Application No: AB/75/21/HH
Site Address: 54 Tarrant Street Arundel BN18 9DN
Description of works: Alterations to fenestration and installation of 4 x new rooflights and waterproofing system to basement and outbuilding. This application may affect the character and appearance of the Arundel Conservation Area and the setting of a listed building.

Thank you for your internet representation made on 28th June 2021 which has been recorded as an objection with the comments as follows:

PROPOSED DETAIL FOR
 WINDOWS W6, W7, W8 + W9
 WHICH WILL BE DOUBLE GLAZED

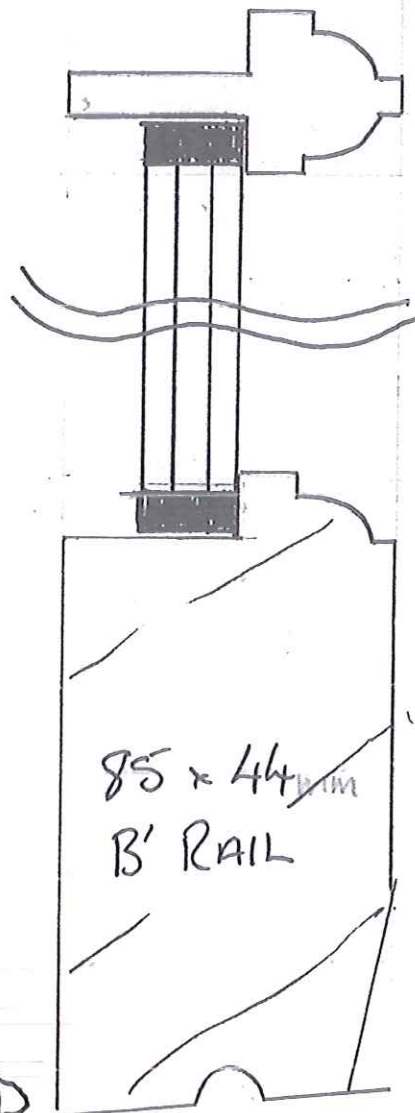
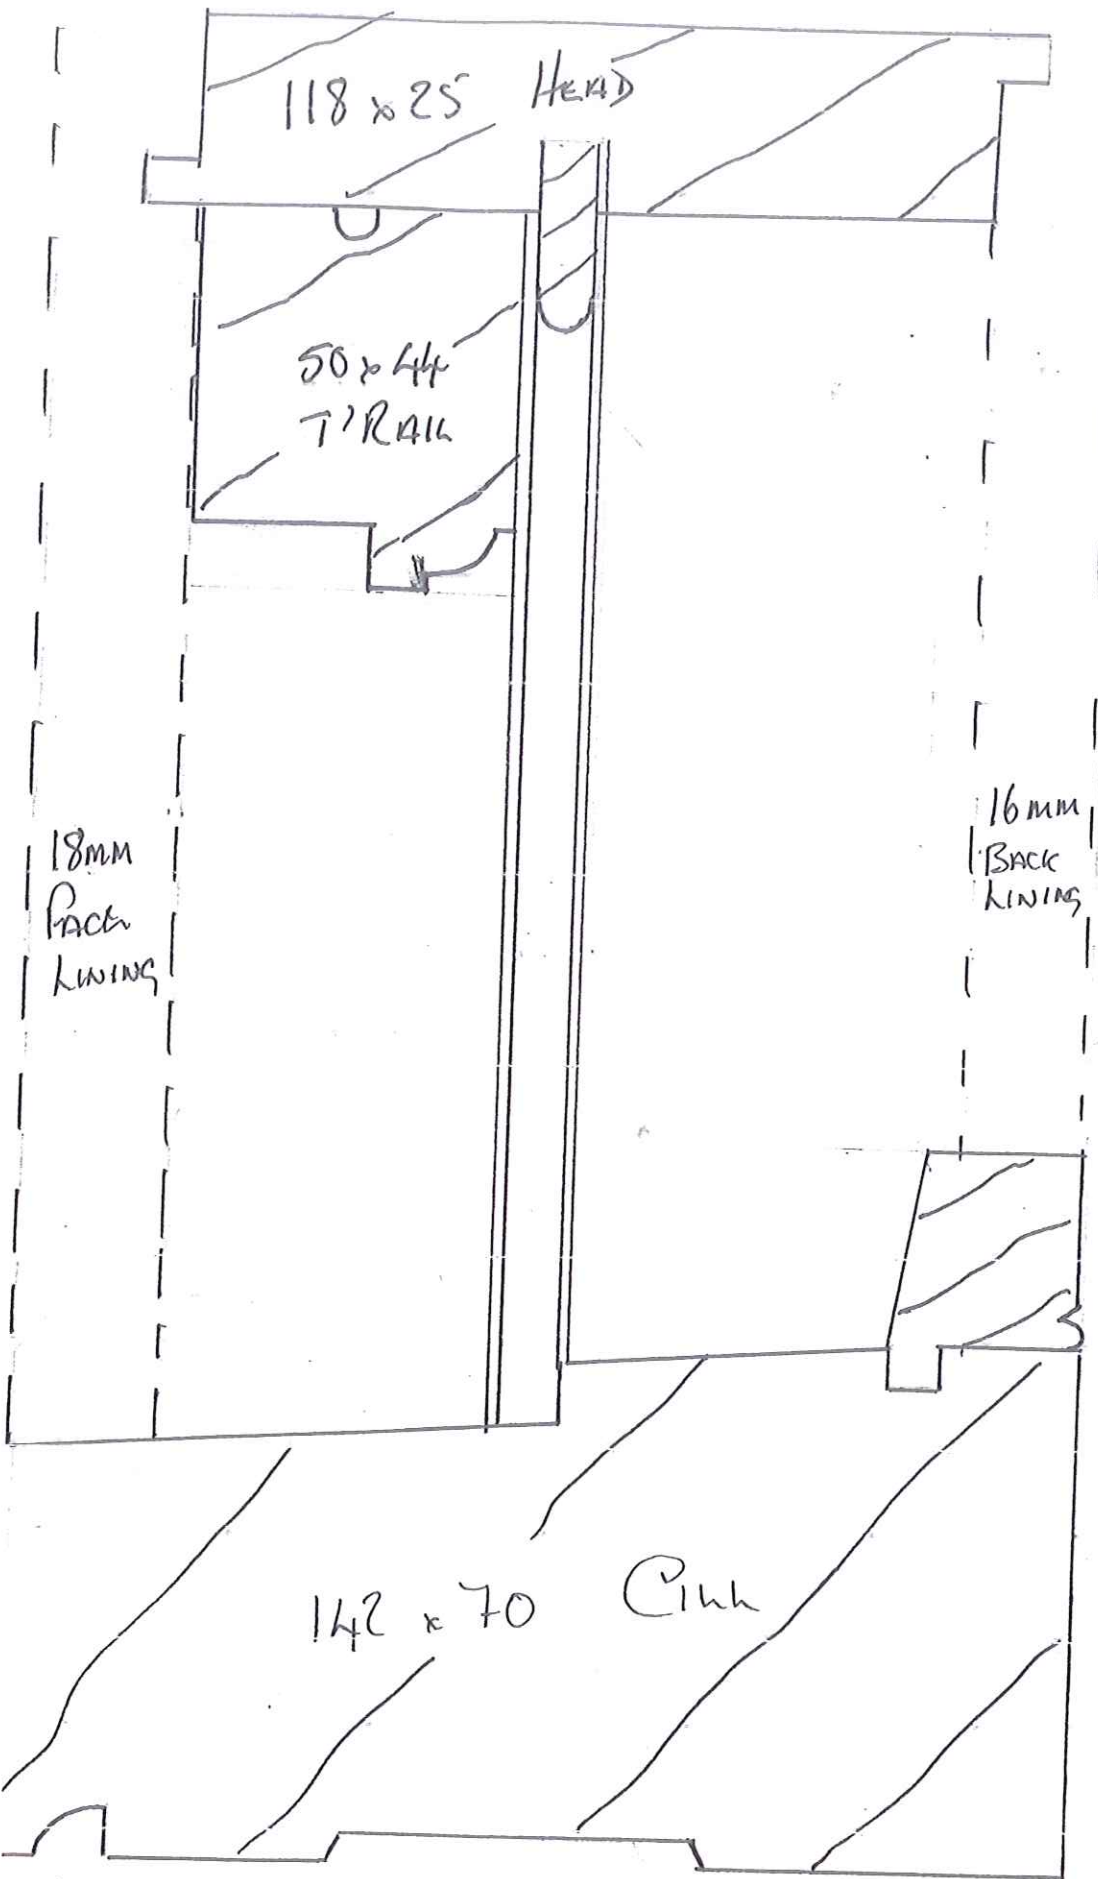
The Committee objected to the Application on the grounds that the double glazed windows cause harm to the character and significance of the Grade II Listed Building and the designated Conservation Area in conflict with HER DM1 and HER DM3 of the Arun Local Plan and the National Planning Policy Framework.
